# CITY OF ALBUQUERQUE

December 31, 2019

**Re: Blake's Lotaburger LLC**  
**1801 Juan Tabo Blvd NE , 87112**  
**30-Day Temporary Certificate of Occupancy**  
**Transportation Development Final Inspection**  
Engineer's/Architect's Stamp dated 4-22-19 (H21D012)  
Certification dated 1-2-20

GRADING AND DRAINAGE PLAN

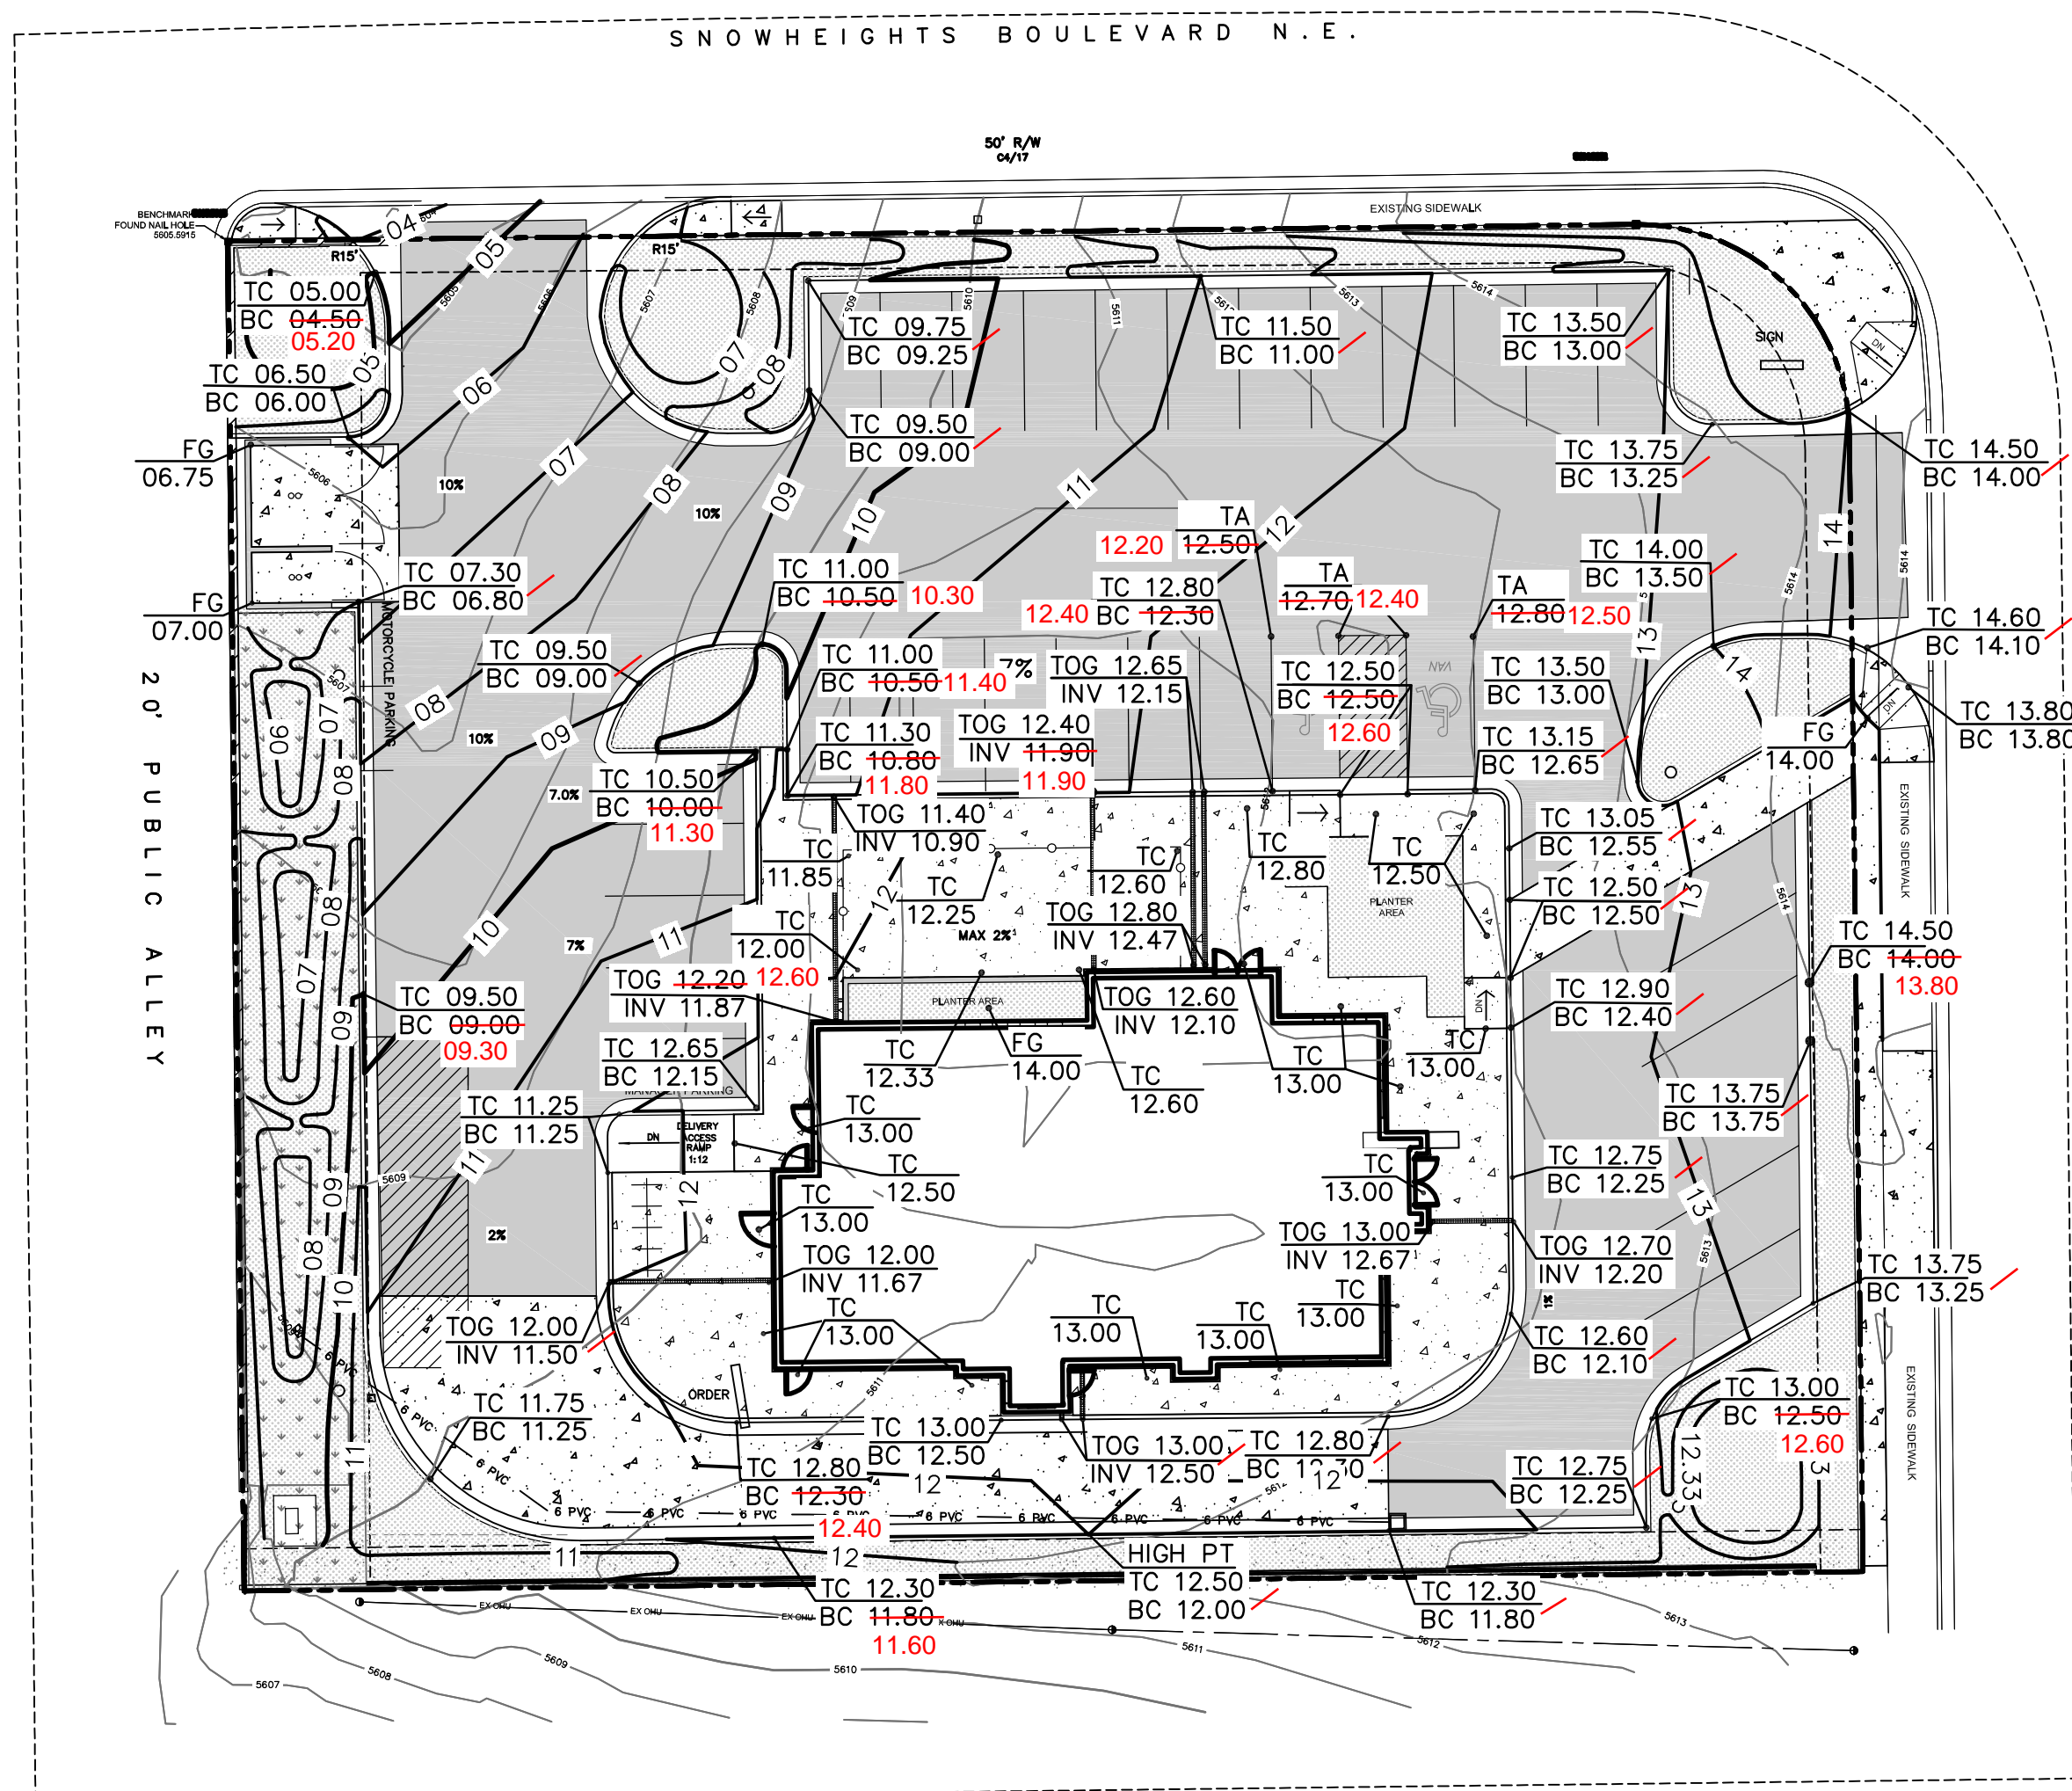
- Please remove landscape rock from parking stalls.
- Please remove security fence.
- Please remove trash container, porty potty, construction equipment and debris.
